Side two storey extension, front dormer, front porch and new detached garage
2 Elm Avenue East Preston

Thank you for your internet representation made on 12th October 2012 which has been recorded as **an objection** with the comments as follows:

I am commenting on this application on behalf of the East Preston and Kingston Preservation Society. ☐

SHEET: PROPOSED PLANS/ELEVS.

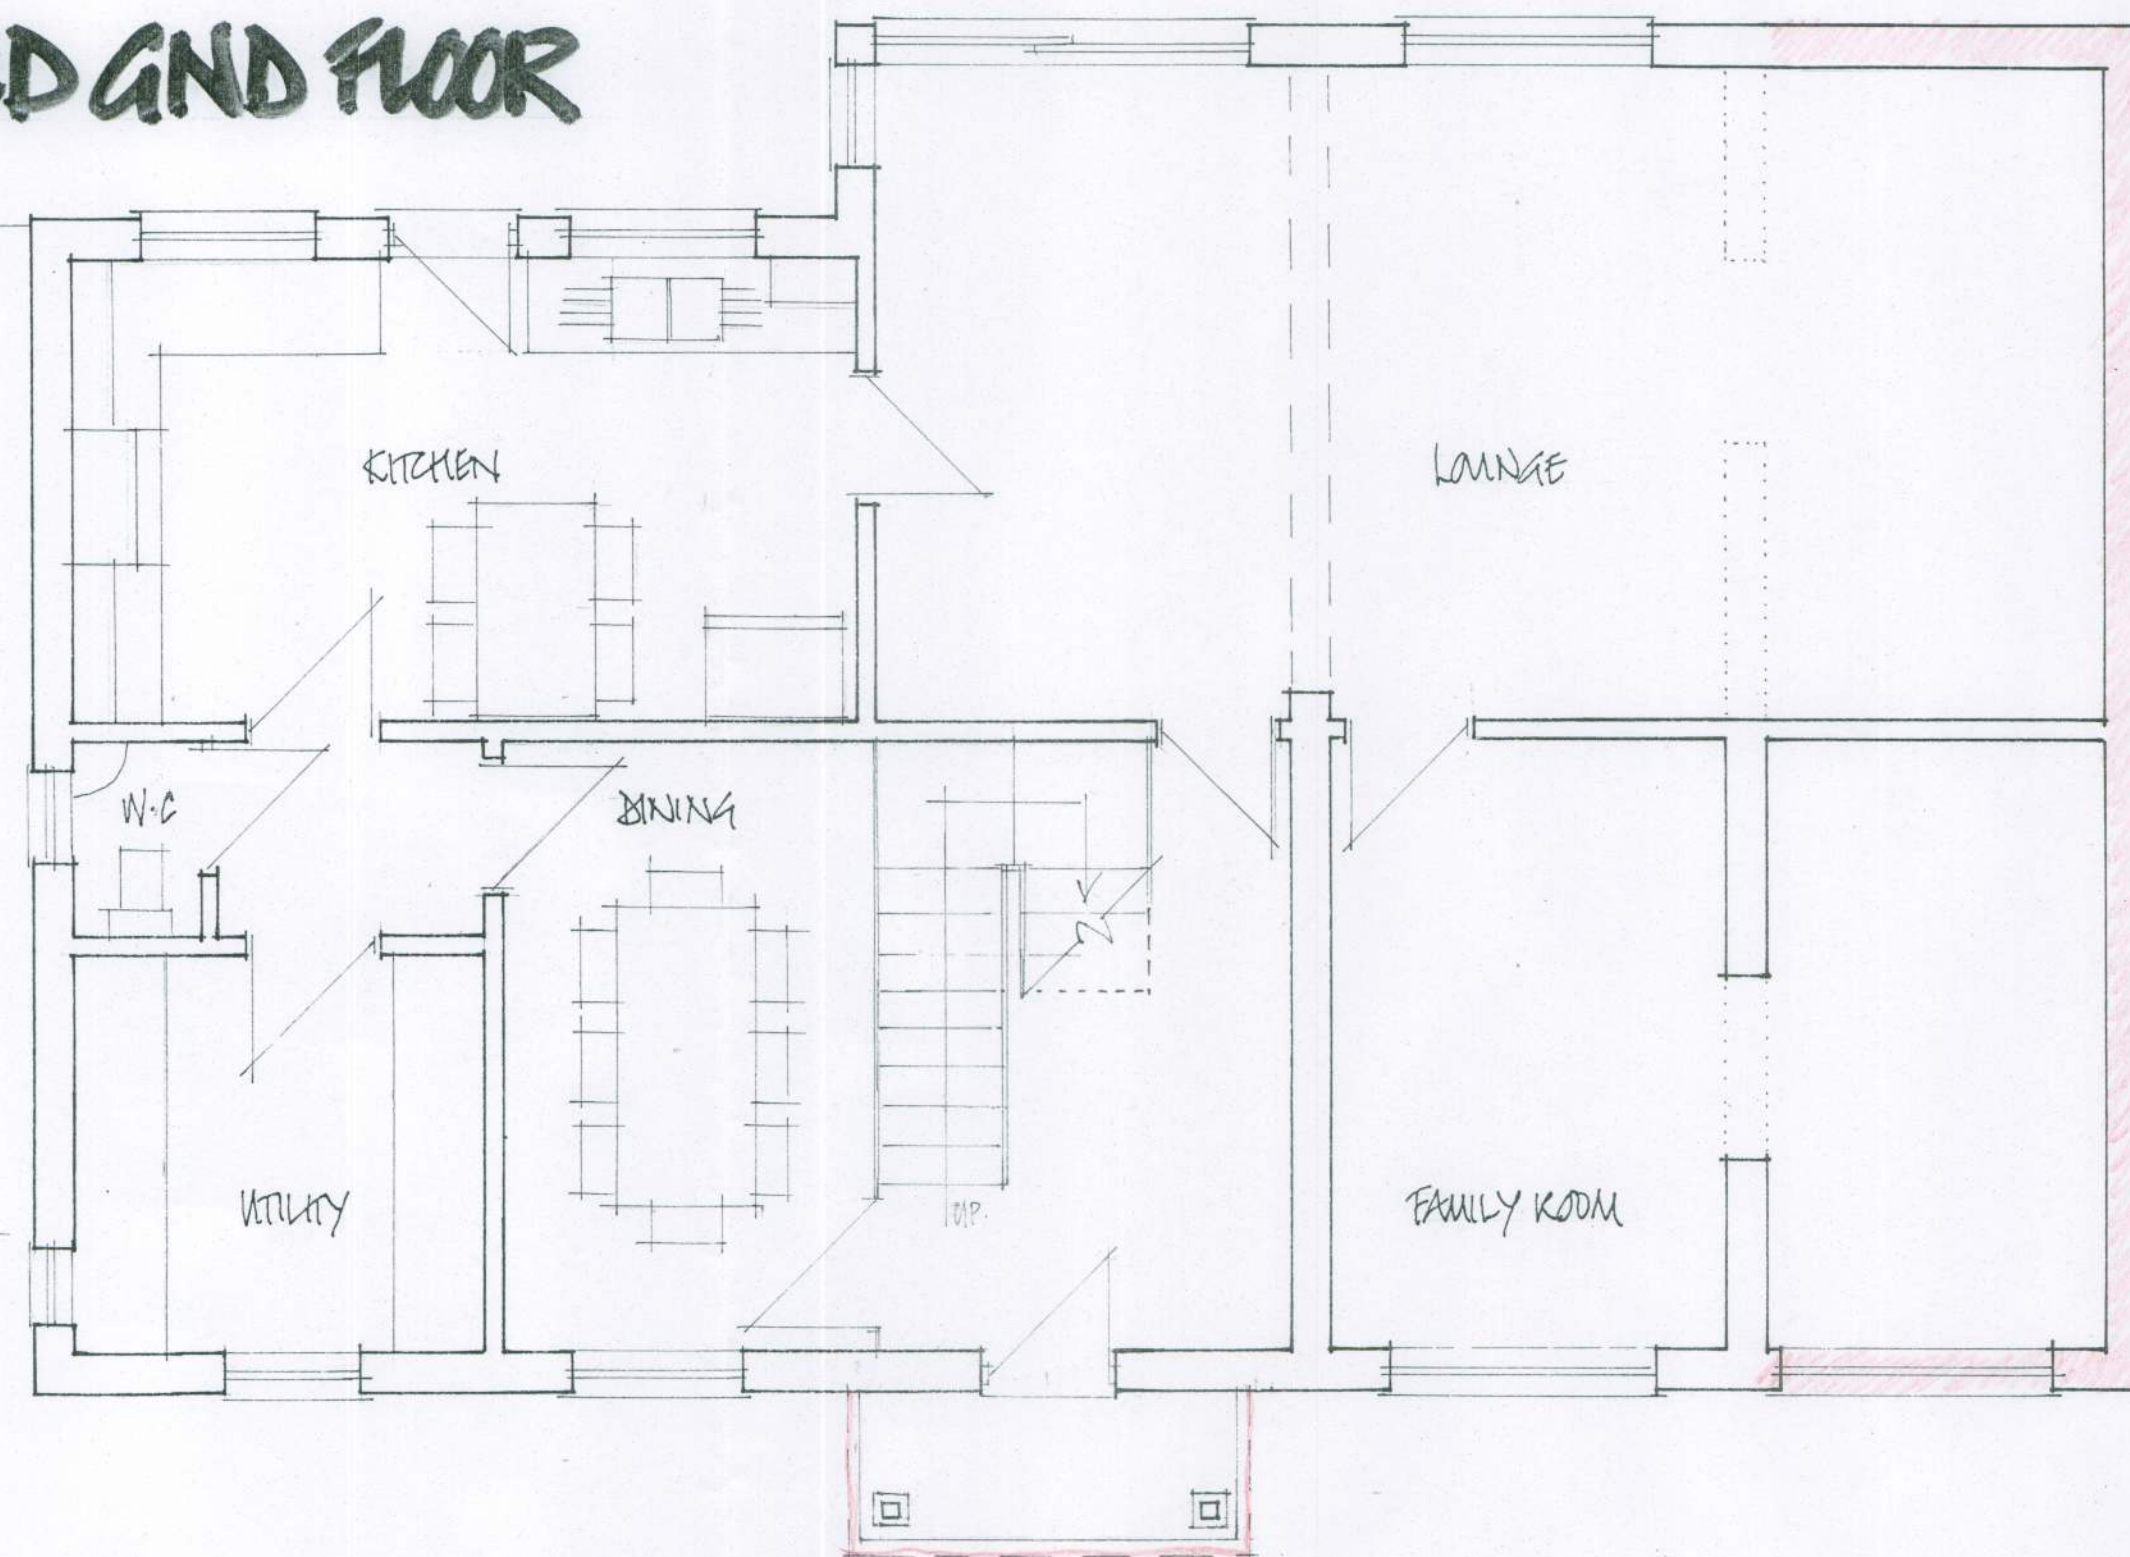
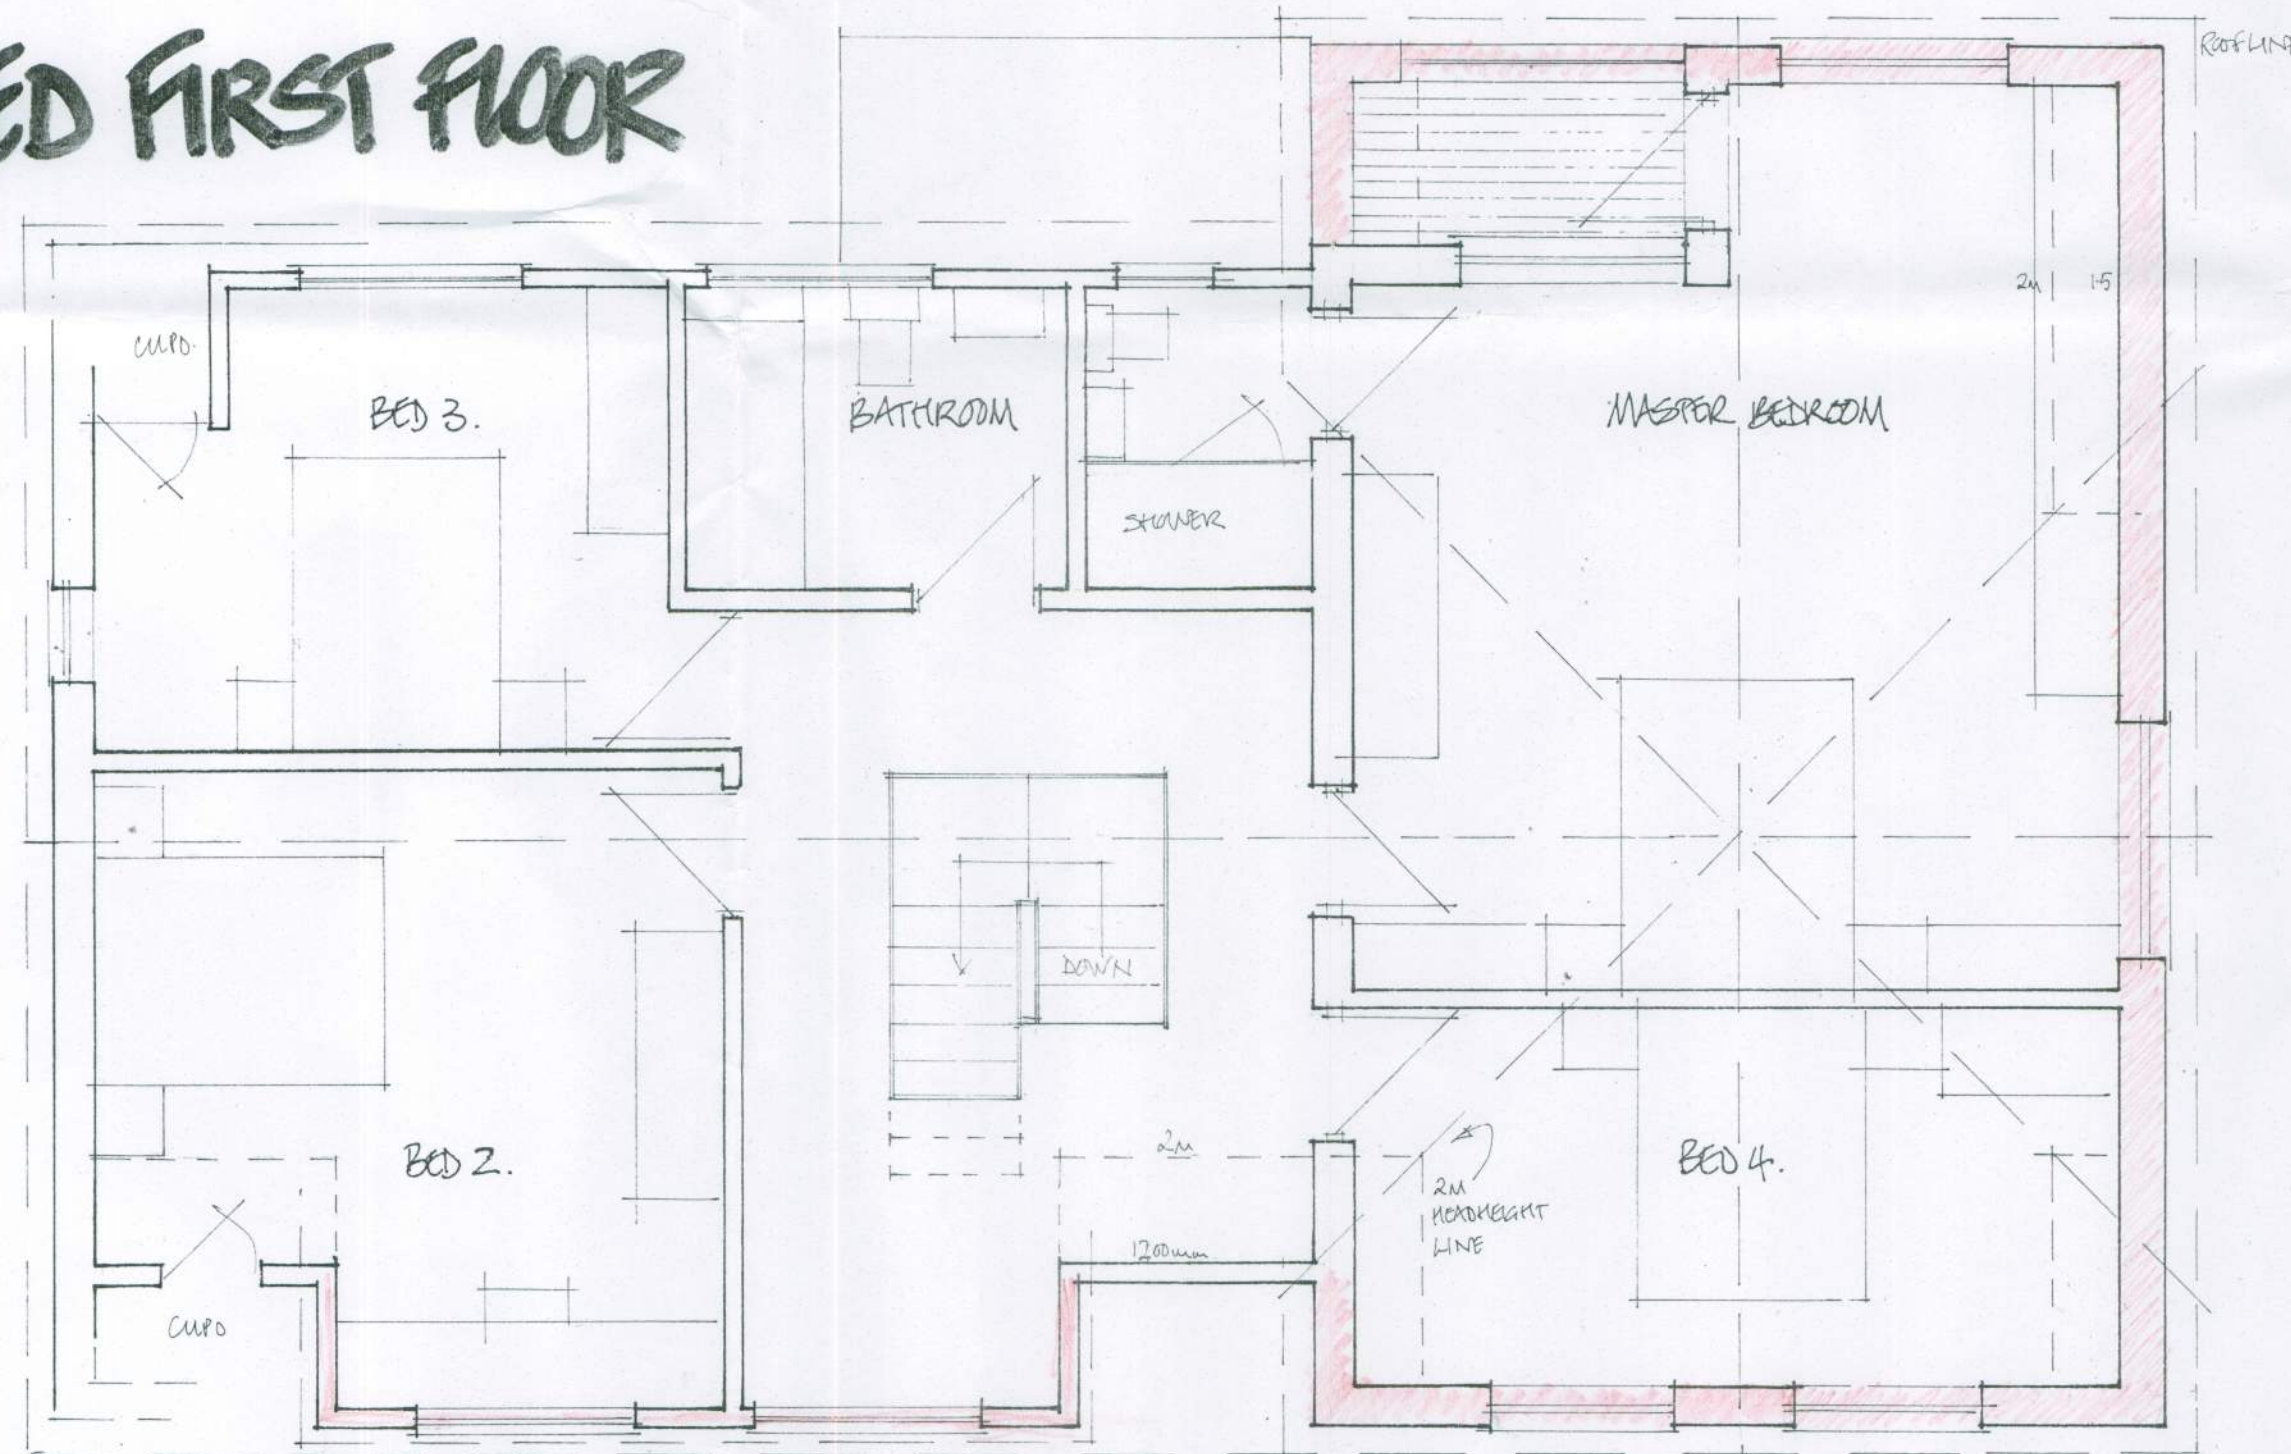
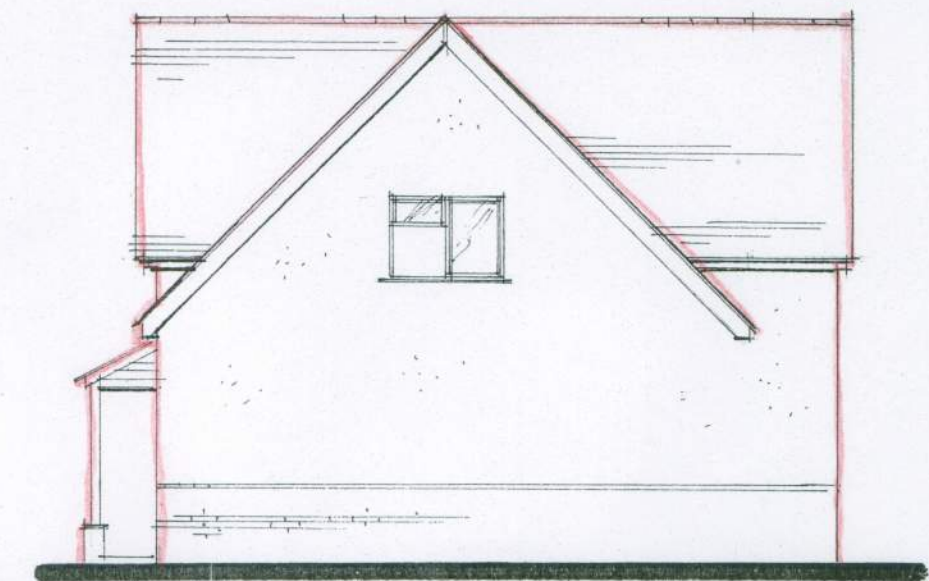
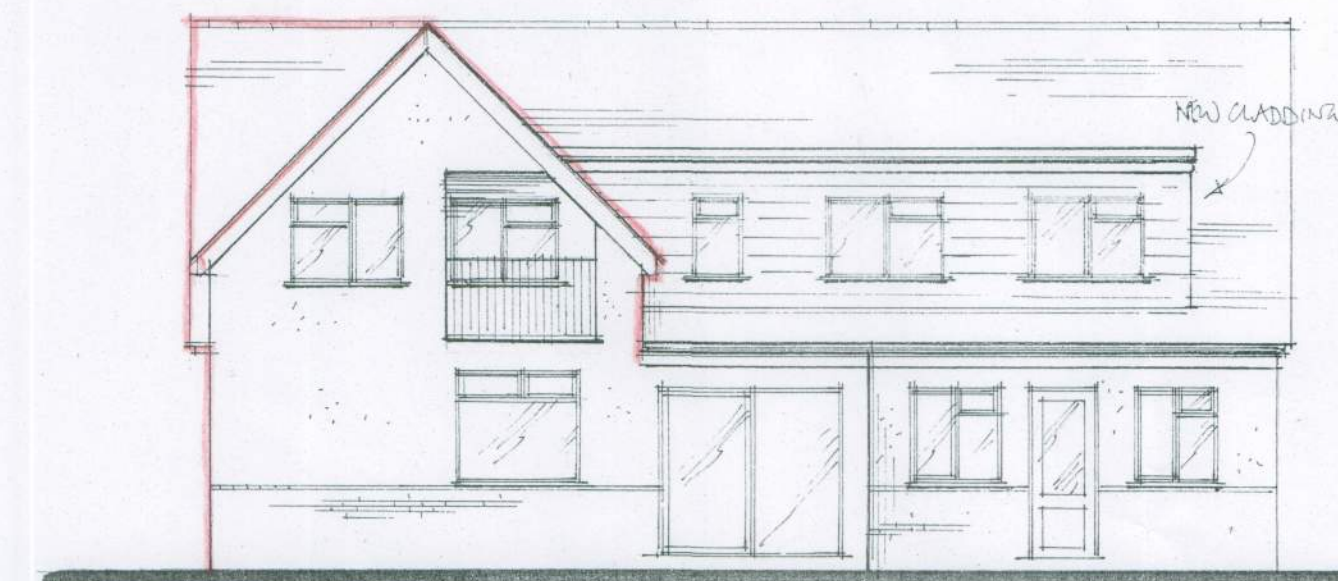
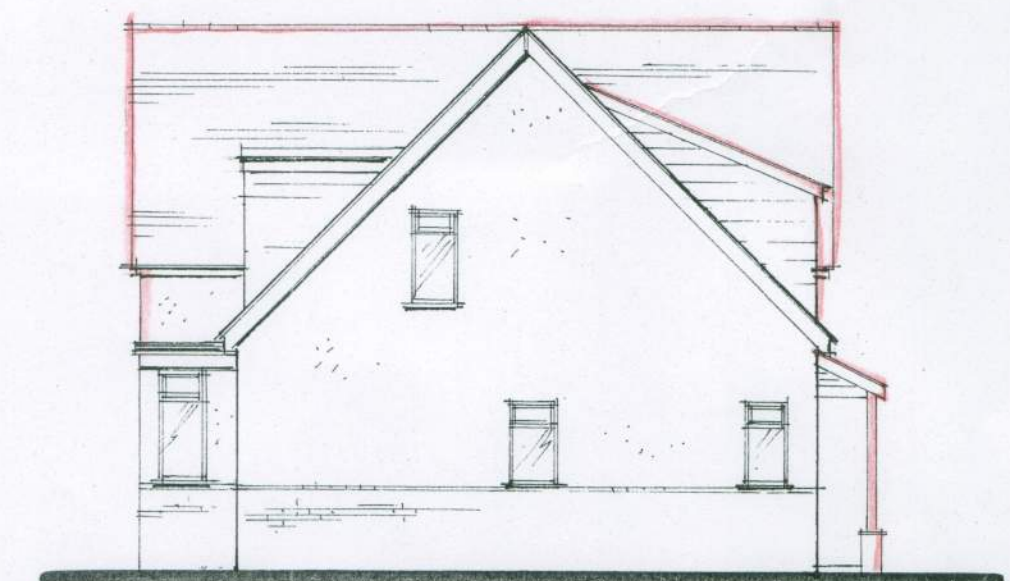
2. The use of shiplack cladding on the new garage and the facade of the house. This material is not used on any other building in the road, and its introduction would be contrary to policy DEV19, because the extension would not be visually integrated with the existing building in materials, while the use of this material on the extension and garage would compromise the pattern of the street; and the use of this material would also be contrary to the guidelines of the East Preston Village Design Statement, which emphasises that materials in new buildings should harmonise in both colour and texture with those in existing buildings in a road. ☐

For these reasons, this application should be refused. It might be acceptable if the garage was omitted, and if the materials used on the house were brick and rendering to match the materials in adjoining houses. ☐
